Project Title: Water Lane, Angmering

Project No/ Document Reference: A290-TN007

DRAINAGE – CONDITIONS DISCHARGE

Scale	Date	Drawn	Checked
1:250 @ A1	JAN 21	JS	SL
Drawing No	Revision		
A290-508	CIV-1-4058 F		F

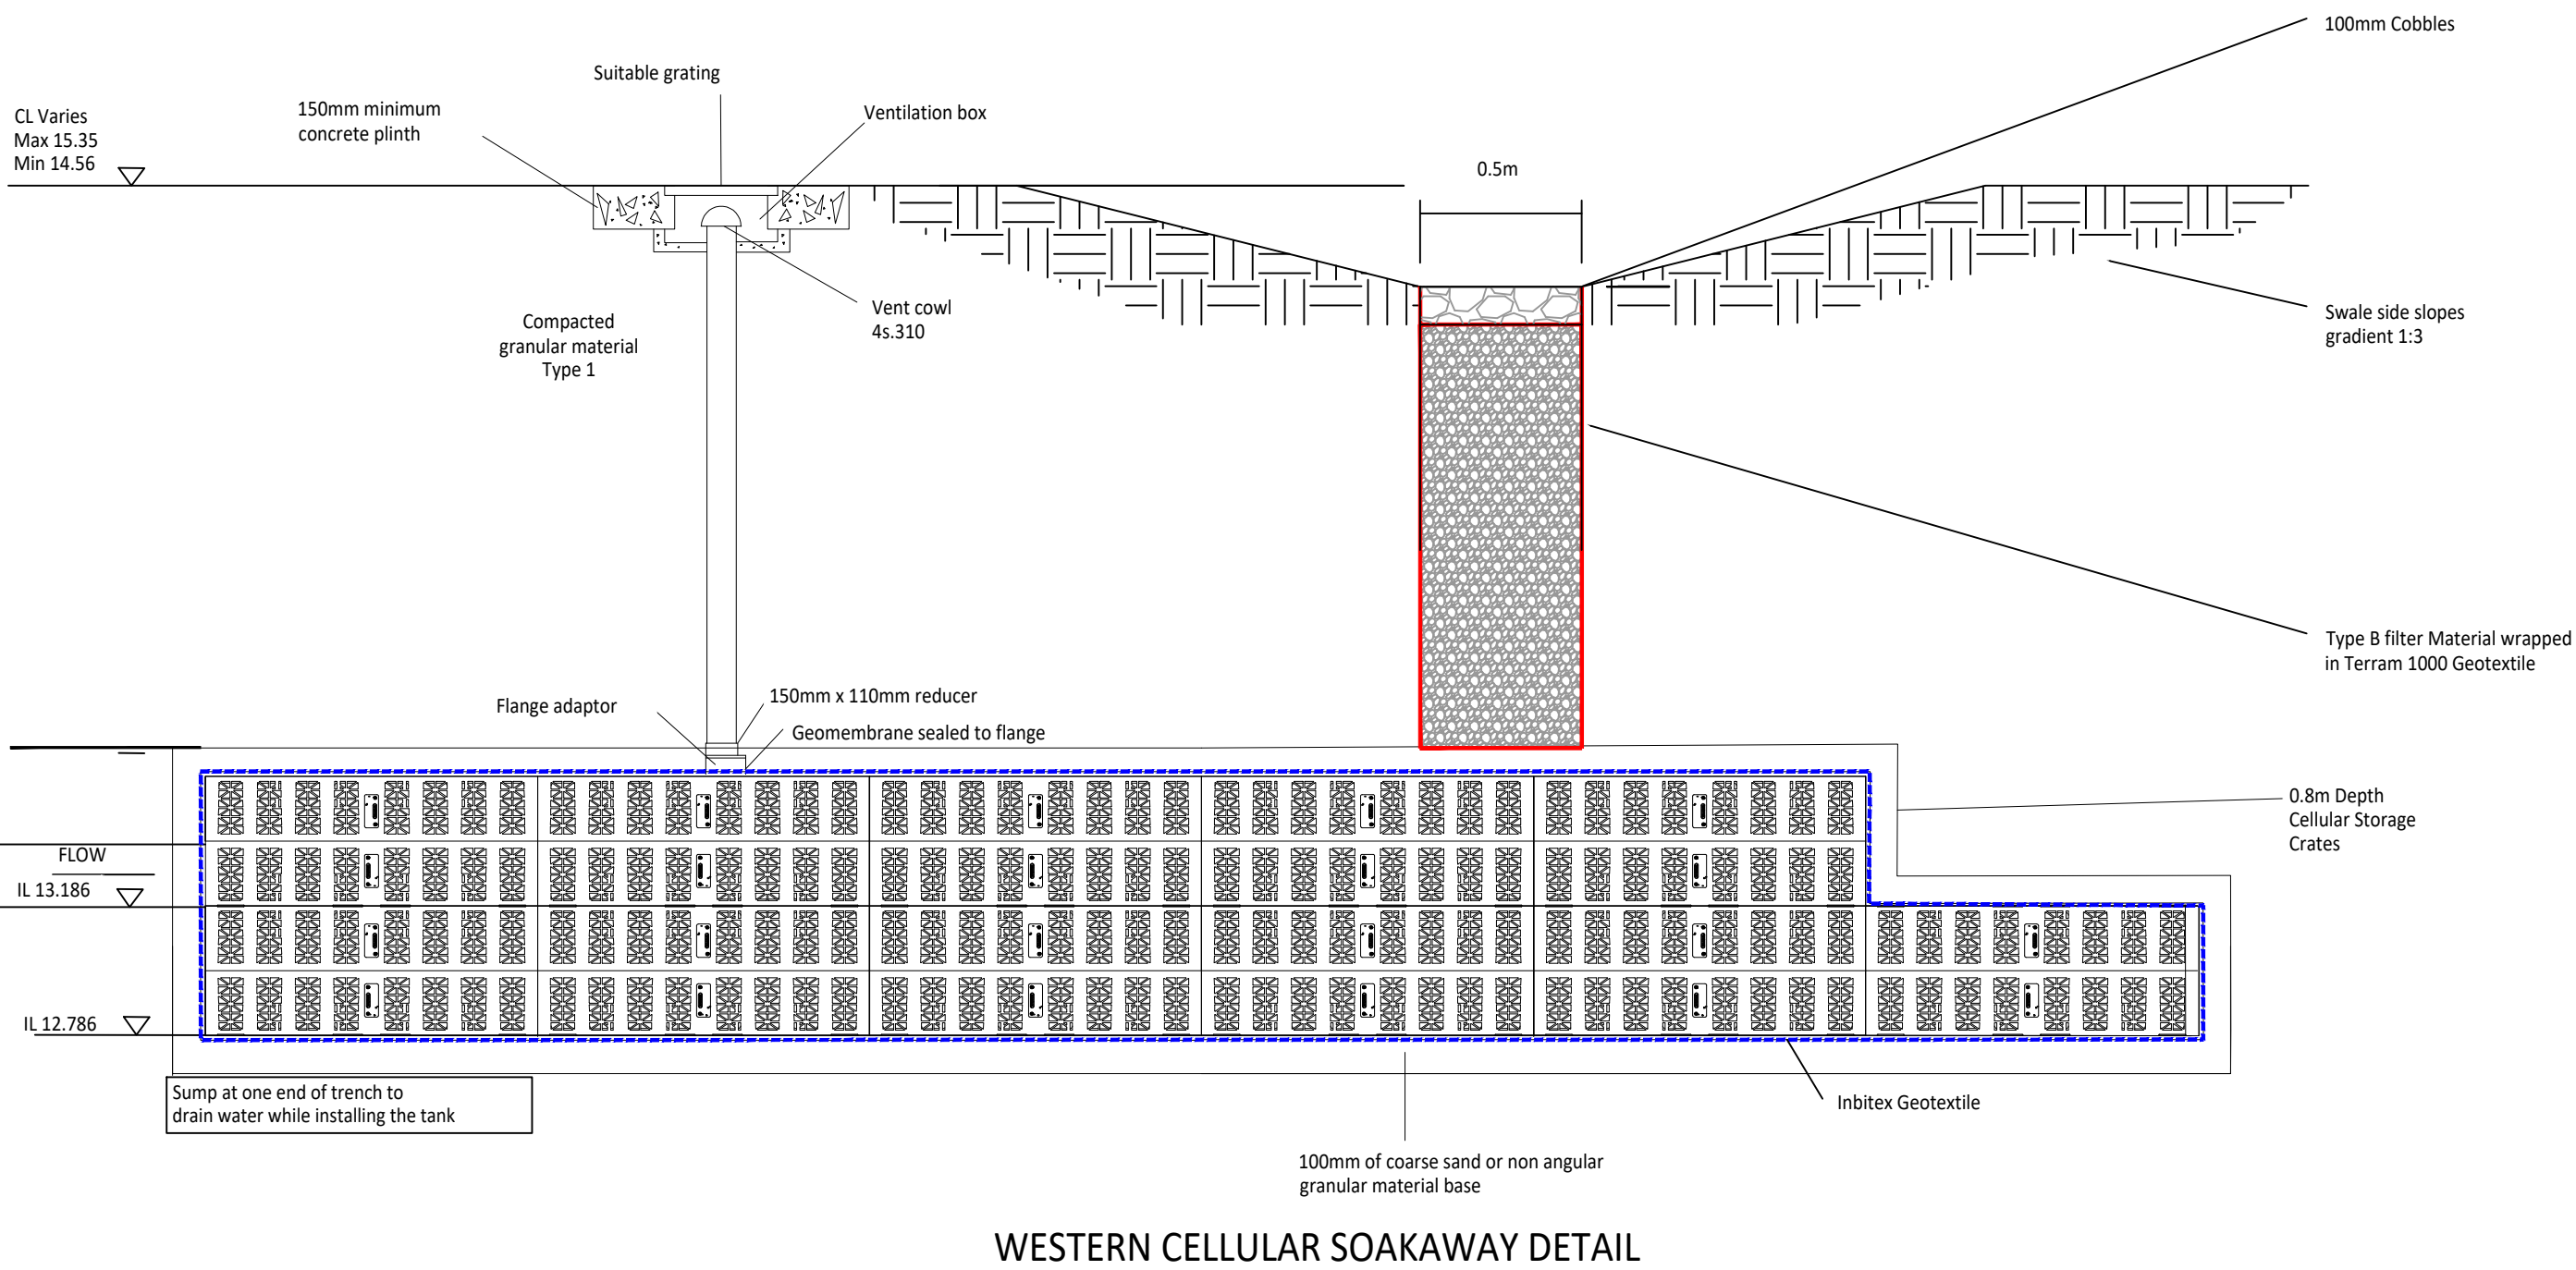
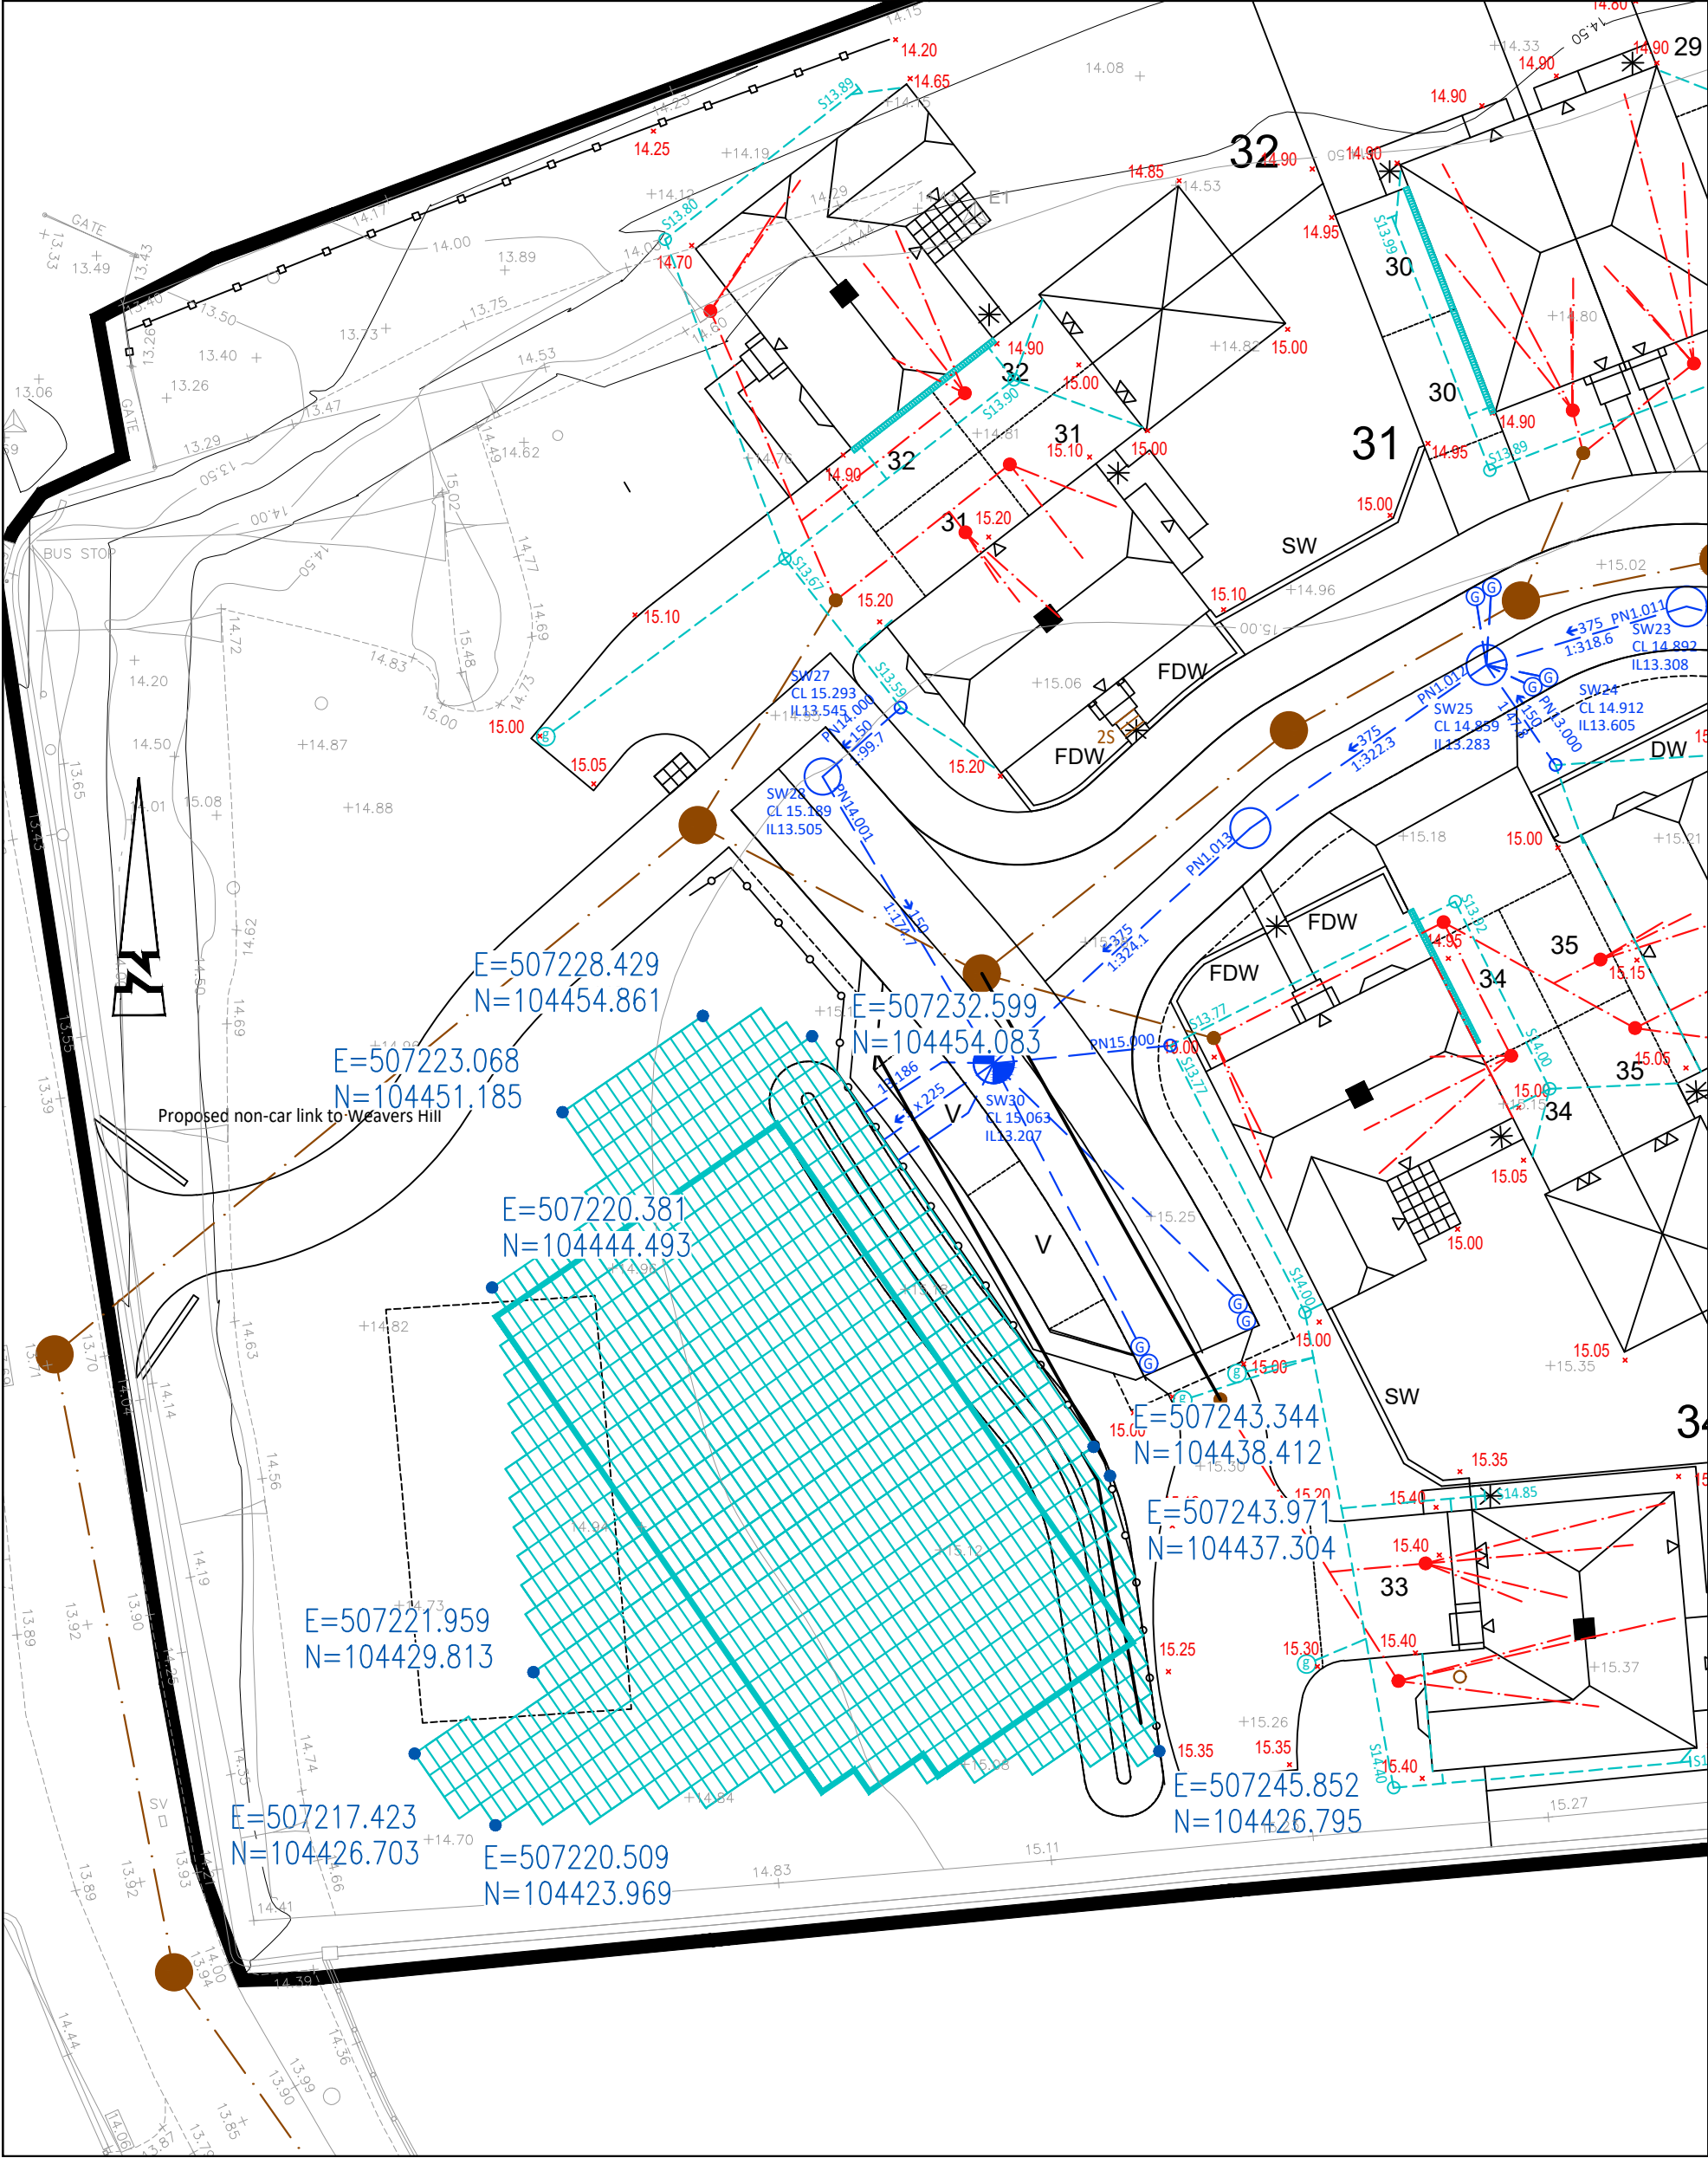
1. *Calculation printouts do not include pipeline schedule printouts of upstream and downstream manholes. This combined with layouts not showing pipe numbers makes it very time consuming to review. I therefore have not reviewed the calculations. Please supply further calculation printouts and include pipe numbers on plan. Please see comments below (24 onwards)*

15. *Please detail swale invert levels, top of bank levels, side slopes, and any bed slope on drainage layout plans.*

19. *Please detail incoming pipe invert levels on the central swales. Please include invert level of swale on plan*

All calculations are provided again and amended as per your comments. All pipe numbers have been included on all plans.

This has been noted and included on the drawings.

This has been noted and included on the drawings, as previously.
